Mr Brendon Roberts  
Team Leader, Key Sites Assessments  
Department of Planning & Environment  
23-33 Bridge Street  
SYDNEY NSW 2000

**Request for comment and recommended consent conditions for a Concept Proposal  
for the redevelopment of Cockle Bay Wharf (SSD 7684)**

**Rajeev Maini**  
A/Manager Conservation  
Heritage Division  
Office of Environment & Heritage  
**As Delegate of the Heritage Council of NSW**  
14 February 2016

Figure 4.2 Plan of the subject site showing assessed archaeological potential. (Source: NSW LPI with GML overlay)

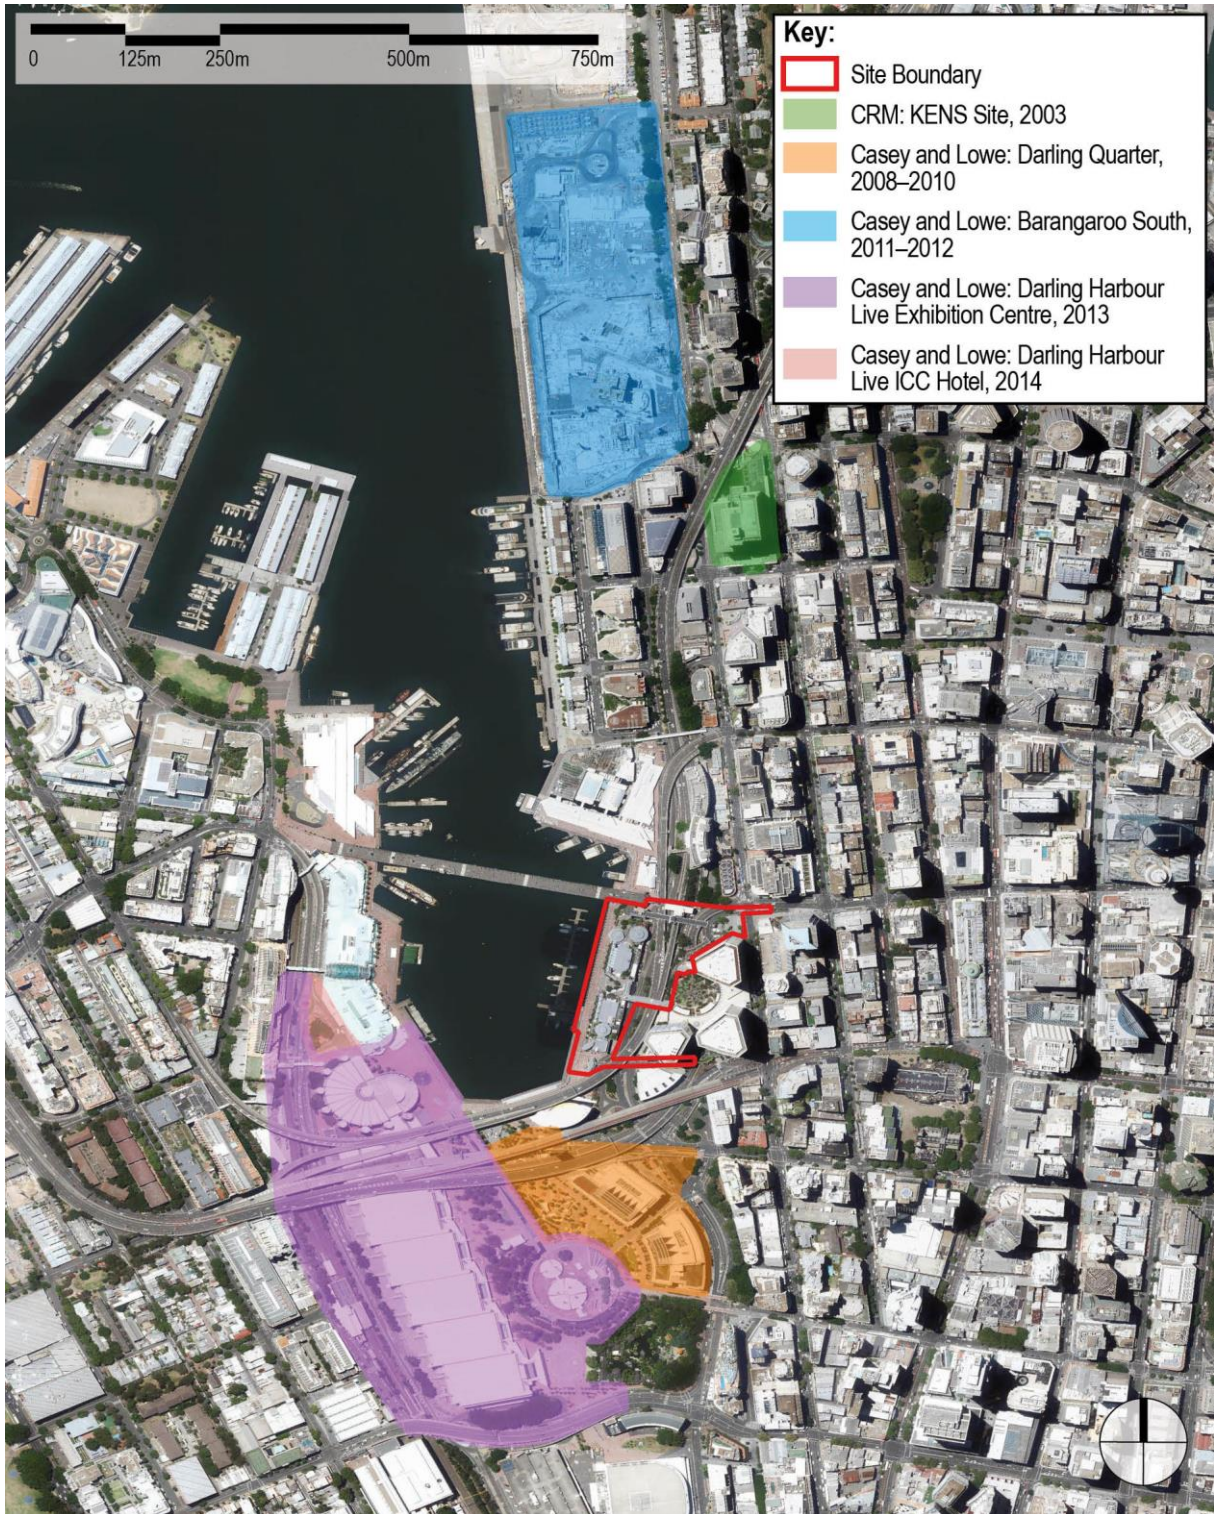
The Assessment prepared by GML Heritage has identified the study area is likely to contain historical archaeological resources of both local and state heritage significance, which will be impacted by the proposed activity.

The impacts of previous developments both in and immediately surrounding the study area are unlikely to have removed evidence of these resources because of those construction impacts are understood to have been fairly limited. This means it is likely the redevelopment will directly harm these resources as currently designed, in particular the demolition of the Cockle Bay Wharf Commercial Tower and the Public Domain Podium/Deck. These resources can contribute information which is not available through other sources of information for the understanding of the development of industrial Sydney.

The impact to potentially state significant archaeological resources is not supported as best practice and should be avoided by the proposed development. However, the proposed approach as recommended by GML Heritage, to undertake test excavation in the first instance to clarify the location of significant archaeological deposits and to redesign to avoid them is supported by the Heritage Division.

8. The Applicant must retain all state significant archaeological resources *in situ* and unharmed. Archaeological test excavation should occur in the first instance to guide redesign to avoid harm to these resources.
